**WELWYN HATFIELD BOROUGH COUNCIL – DEVELOPMENT MANAGEMENT  
DELEGATED REPORT**

<b>APPLICATION No:</b>	<b>S6/2013/0270/FP</b>
<b>APPLICATION Site:</b>	<b>65 Bramble Road, Hatfield</b>

Erection of single storey rear extension

Drawing Number
J1027/P04 Revision

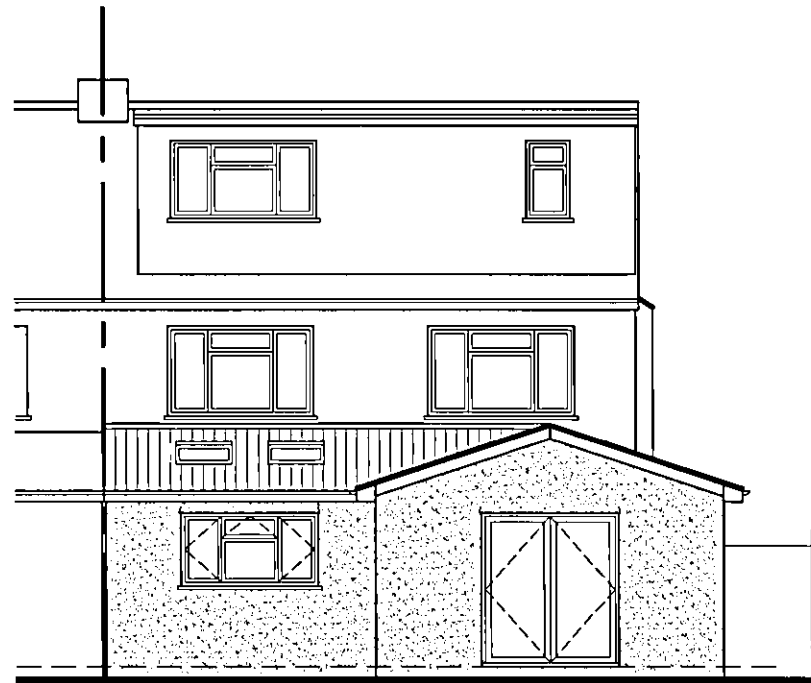
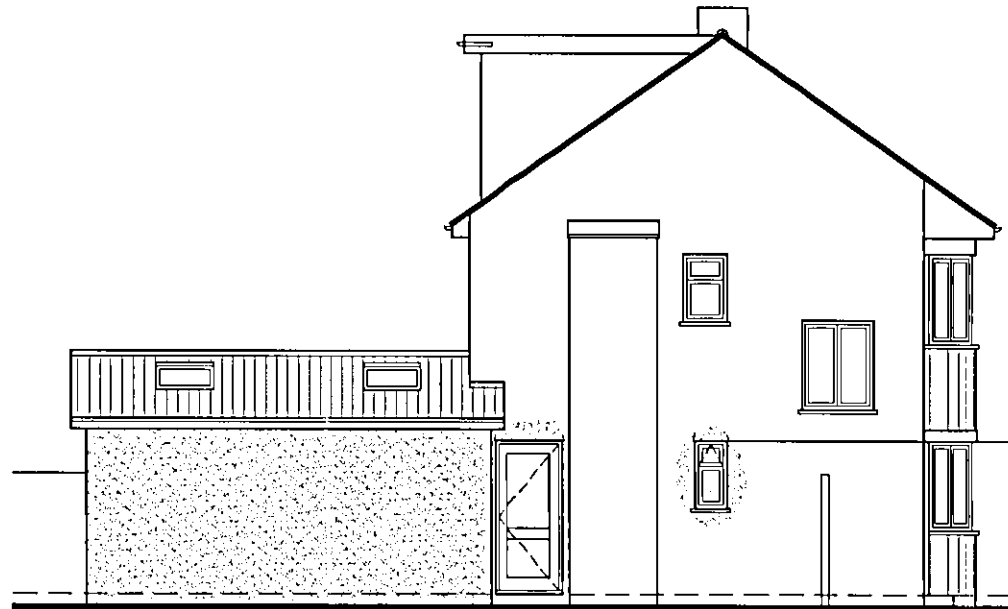
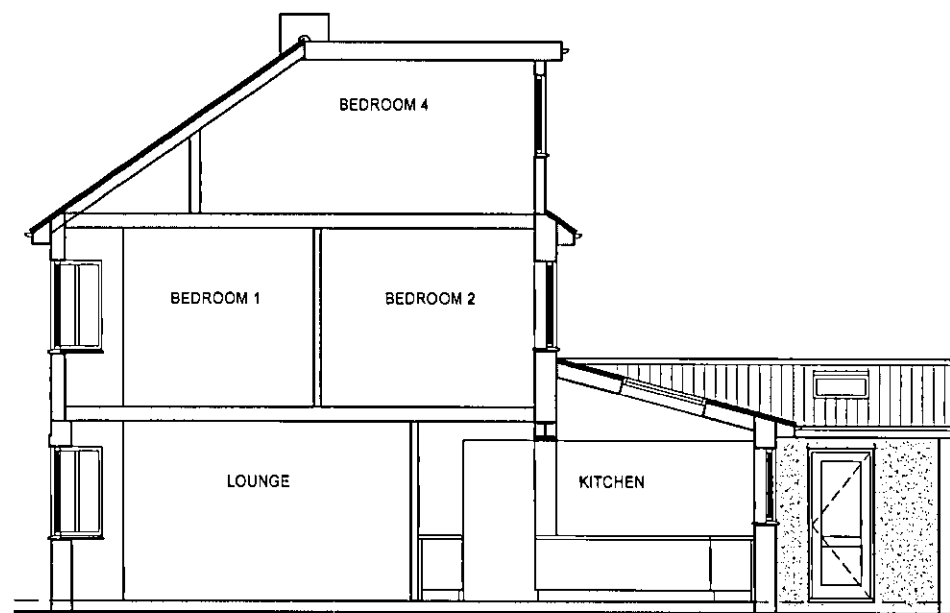
The proposed extension is to create a new family room and kitchen area which will require a single storey rear extension which will be approximately 3m deep alongside the boundary with No.67 and will extend to a maximum depth of approximately 5.25m towards the side boundary with No.63. It is proposed to use a pitched roof which will have a gable end, with four rooflights.

The existing walls are white painted render and the proposal is to use the same external wall finish to match. The existing roof tiles are concrete interlocking and these will also be matching on the new extension.

Taking into account the use of matching materials, and that the design of the extension is of an appropriate scale and depth, the proposal is considered to be in keeping with the character of the parent property. A planning condition requiring the use of matching materials would be reasonable to ensure that the proposal is of a good design quality.

3. C5.2 Matching materials
4. The ground floor side window to the proposed WC in the existing building shall be glazed with obscured glass and shall be fixed so as to be incapable of being opened below a height of 1.8 metres above floor level, and shall be retained in that form thereafter.

Scale	1:100	@	A3
Date	FEB 13	Drawn	JDM
Drawing Number	J1027/P03	Revision

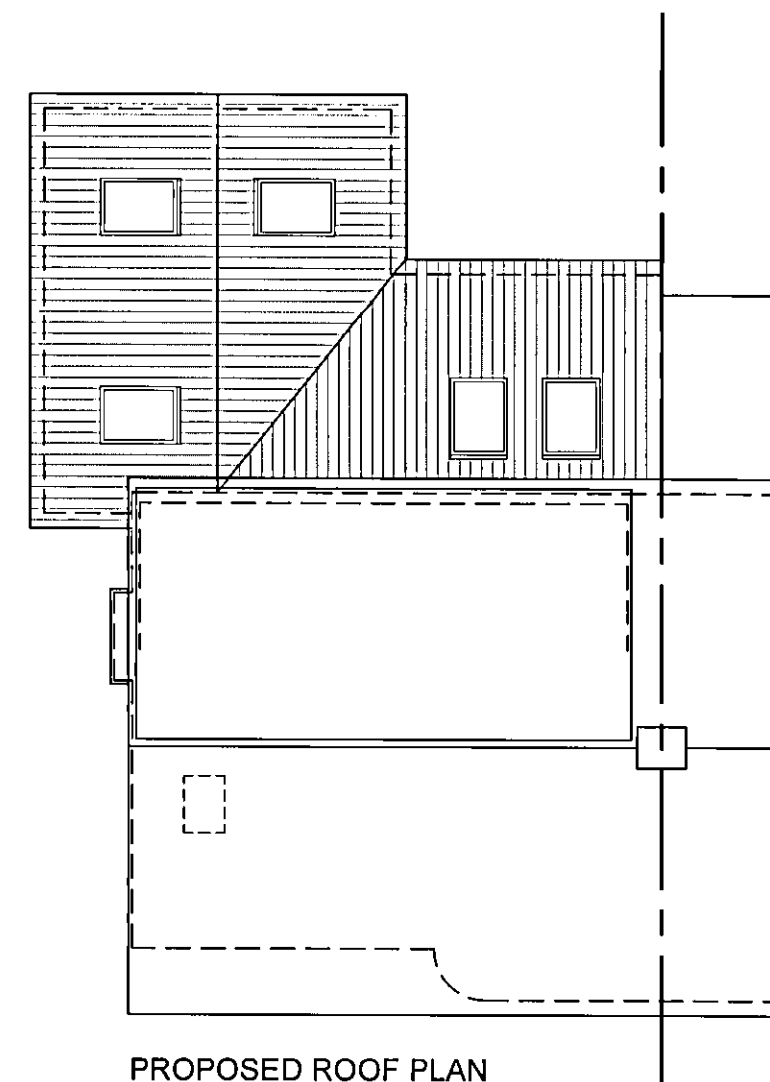
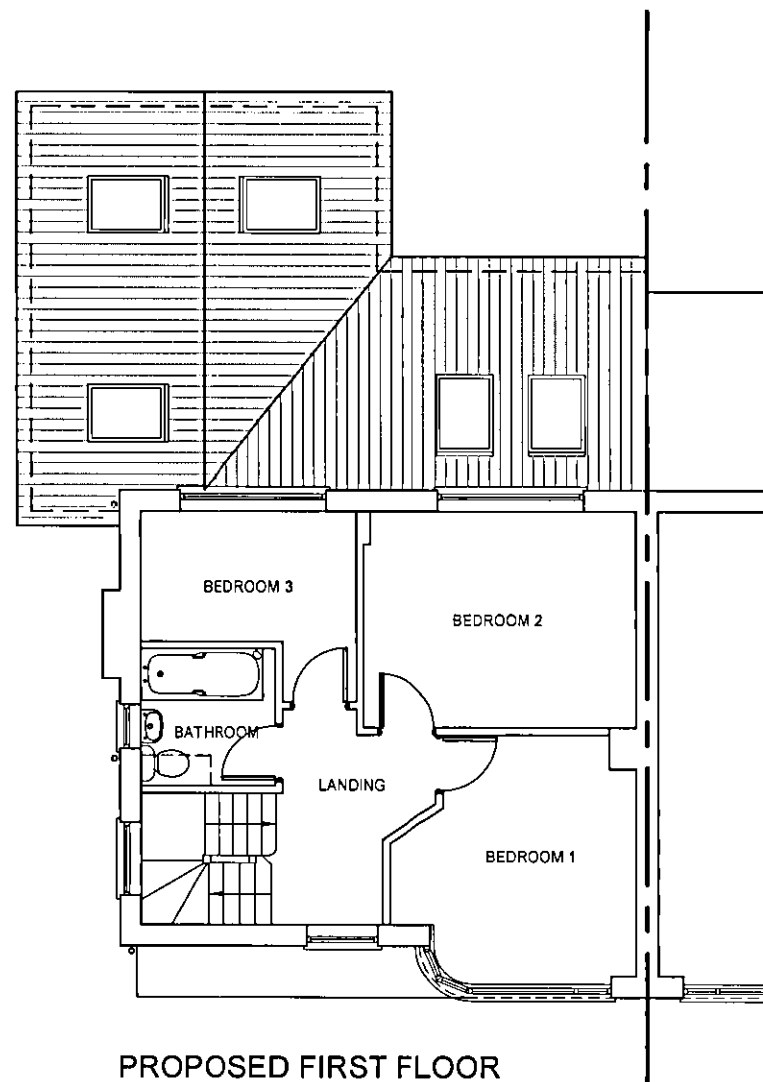
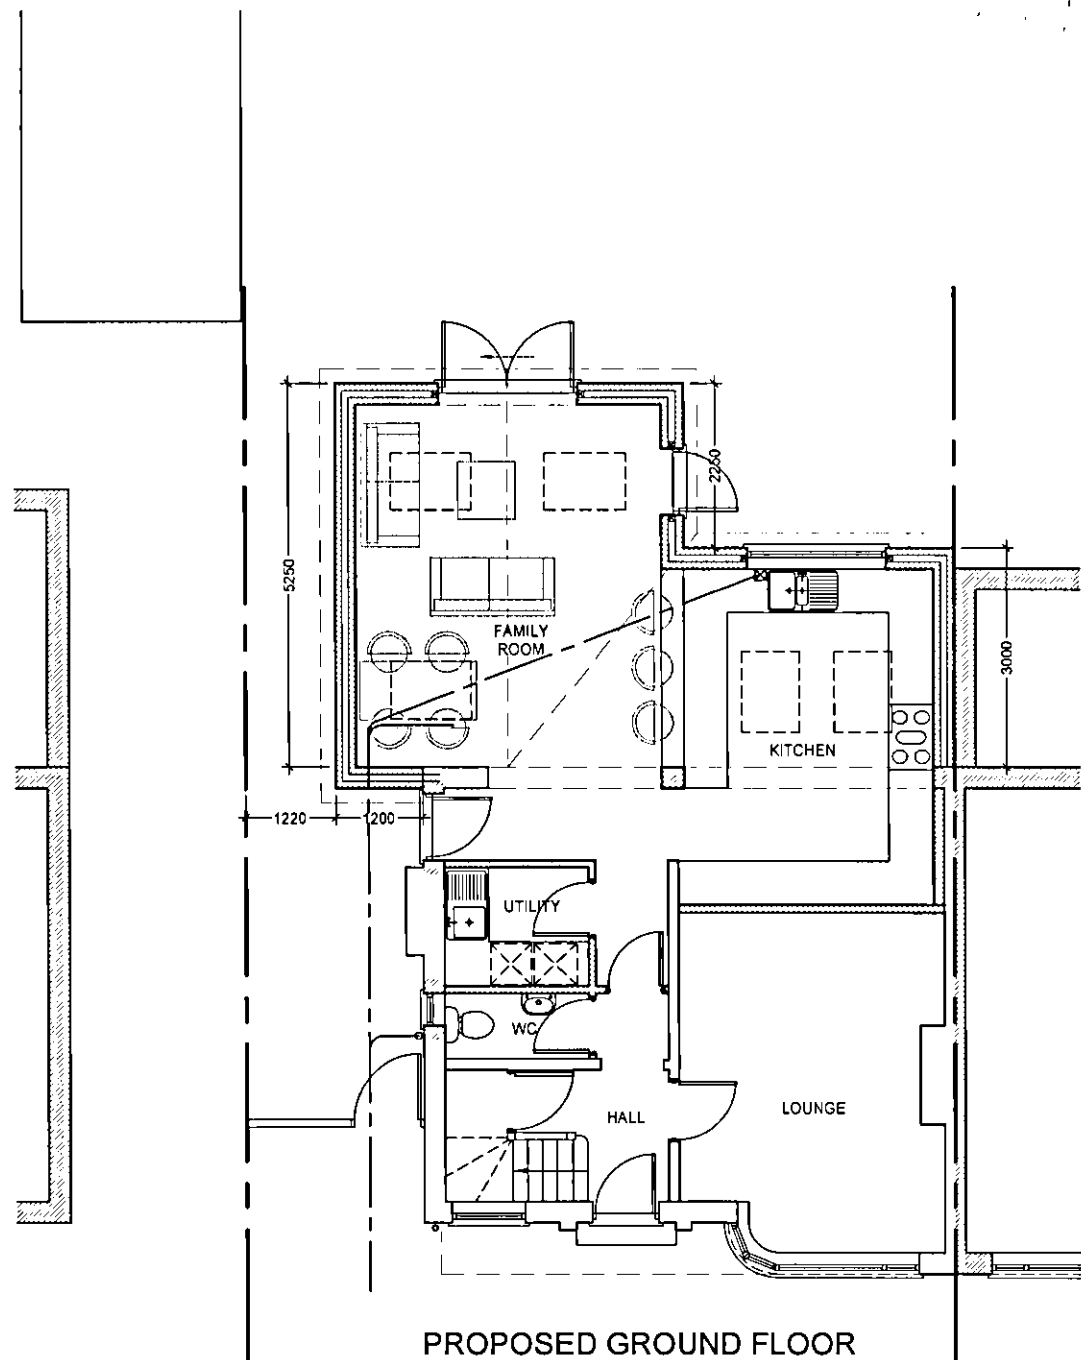
In regards to No.63, the extension will be setback approximately 1.2m from the common boundary with this neighbour. The proposal will extend approximately 1m deeper than the rear wall of this neighbour. Taking into account this set back from the boundary and the limited depth of projection beyond this neighbour's rear wall, it is considered that there will be no harmful impact on this adjoining neighbour's residential amenity, as there will be no significant loss of sunlight/daylight due to the limited height and location of the extension.

Furthermore, the proposal will not appear either overbearing or over dominant when viewed from this adjoining neighbour as the extension is single storey and does not project overly deep beyond the existing rear wall of this neighbour. No side windows are proposed in the new extension which would result in any overlooking to the adjoining neighbour.

A new side window is proposed in the existing wall for a WC, and whilst a close boarded boundary fence gives some screening, it would not be unreasonable to impose a planning condition requiring the use of obscure glazing for this window and for it to be non-opening below 1.8m from floor level for the sake of good neighbourliness.
